Recommendation Report for

REF NO: EG/43/12/

LOCATION: Eastergate C of E Primary School
Church Lane
Eastergate

PROPOSAL: Application under Regulation 3 of the Town & Country Planning General Regulations 1992 for a proposed containerised biomass boiler (this application will be determined by West Sussex County Council)

DOUCH ECO 1 SRINGHILL ORCHARD, WEIRWOOD, FOREST ROW, EAST SUSSEX, RH18 5HT. 01342 825143
DRAWING NUMBER: 0029 010
DRAWN BY: AK
DATE: 04/04/2012
SCALE: 1:50 @ A3
CLIENT: JUDE HOLLAND
ADDRESS: EASTERGATE PRIMARY SCHOOL
TITLE: BOILER SECTION A A
REVISION: 1
NOTES:

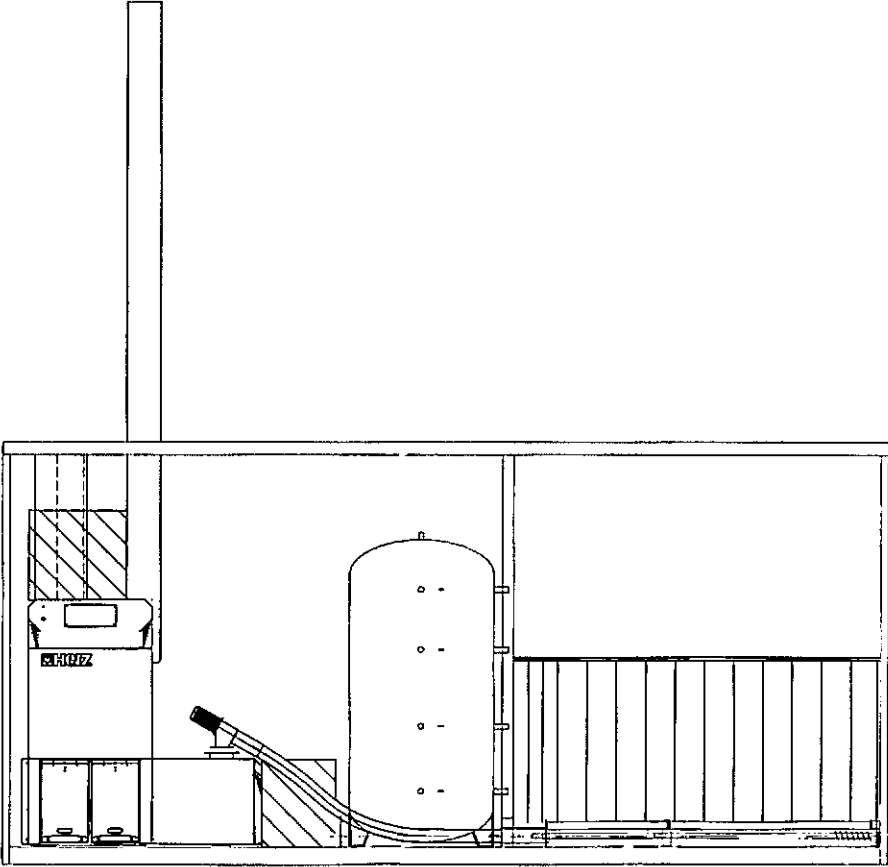
In addition to the above, it is a requirement under the Clean Air Act that all new furnaces >16.12kW are notified to this authority and are capable of operating without emitting smoke. Furnaces burning solid fuel at >45.4kg/h require approval from this authority in respect of their grit and dust arrestment plant. Such furnaces also require approval from this authority in respect of the proposed chimney height, which cannot be readily ascertained from the submitted details. We are unable to approve a proposed chimney height unless we are satisfied that it will be sufficient to prevent emissions becoming prejudicial to health or a nuisance. The stack height must therefore be identified and evidence presented to demonstrate that predicted emissions associated with the calculated stack height will not unreasonably impact upon the area. Dispersion modelling may be required to ascertain an appropriate stack height.

The containerised storage unit in which the biomass boiler will be housed, will measure 5.9 metres in length x 2.8 metres in height x 2.4 metres in depth. It will be clad in timber. A flue, 6 metres above ground level, will be positioned at one end. The boiler will be housed within a steel shipping container to mitigate noise impact. It will be operational during school hours only.

of the boiler is mitigated by its position at the northwest corner of the school carpark. However, it is a utilitarian structure of poor visual appearance that is not considered to preserve or enhance the rural character of the adjoining Conservation Area.

With regards to air quality, contamination and noise, there is residential development to the north east and the west of the site. The public house and garden is located immediately to the north of the school carpark. Environmental Health Officers have provided detailed comments regarding air quality and noise. There is currently a lack of information regarding the boiler, air emission data, fuel storage, dispersion modelling to ascertain an appropriate stack height for the flue and noise produced by the plant.

DOUCH ECO
1 SRINGHILL ORCHARD, WEIRWOOD, FOREST ROW, EAST SUSSEX, RH18 5HT. 01342 825143
DRAWING NUMBER: 0029 011
DRAWN BY: AK
DATE: 04/04/2012
SCALE: 1:50 @ A3
CLIENT: JUDE HOLLAND
ADDRESS: EASTERGATE PRIMARY SCHOOL
TITLE: BOILER PLAN
REVISION: 1
NOTES:

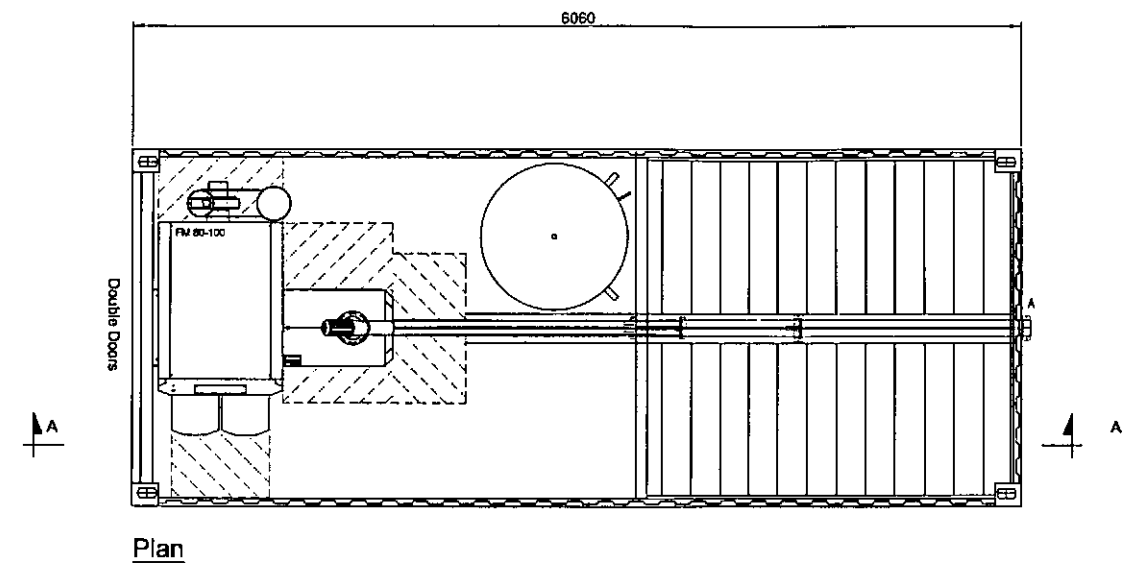
The application proposes the use of pelletised fuel which will have consistent size, geometry and moisture content (a condition might be considered in respect of fuel specification). No detail is provided in respect of fuel storage.

The Air Quality Assessment appears to provide emission data for a range of boilers and does not identify the proposed plant.

No details are provided in respect of noise produced by the plant. The proposal states that the boiler will only operate during school hours as noted; it may be necessary to confirm this by condition.
